Planning Services Sign Permit Review Form

Date of Submittal	Application Number	Applicant	Landowner
10/10/18	SIGN1809-0003	A + L Properties	A + L Properties

Comments	Manufactured Home Park Sign
----------	-----------------------------

One 4' x 8' -1/4" ACM Panel with Vinyl design plus Post & Panel kit \$985.00 plus tax

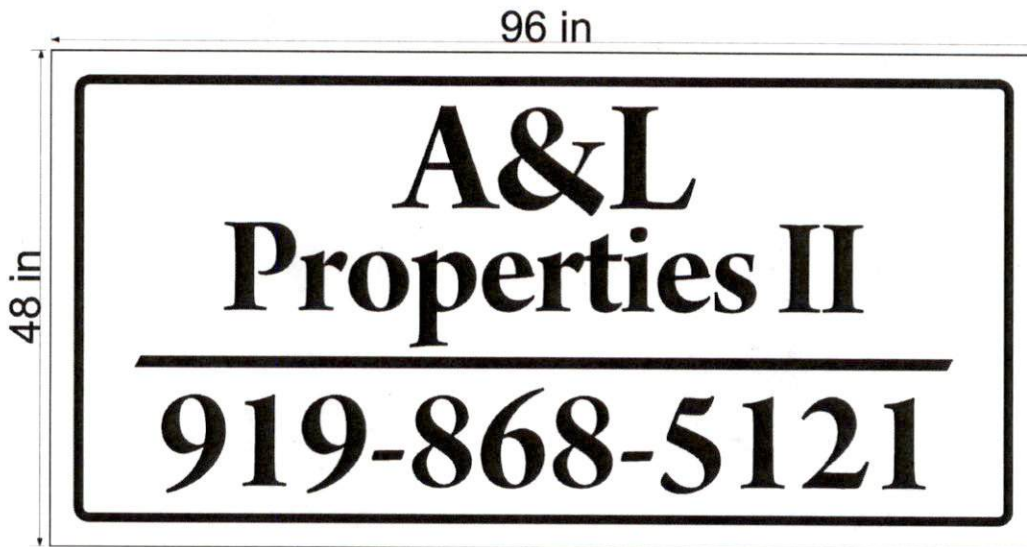
- ~~✓ 1. Note height of sign - max 12 ft - 8 ft tall~~
- ~~✓ 2. Pole must be encased - at least 1 ft wide per pole~~
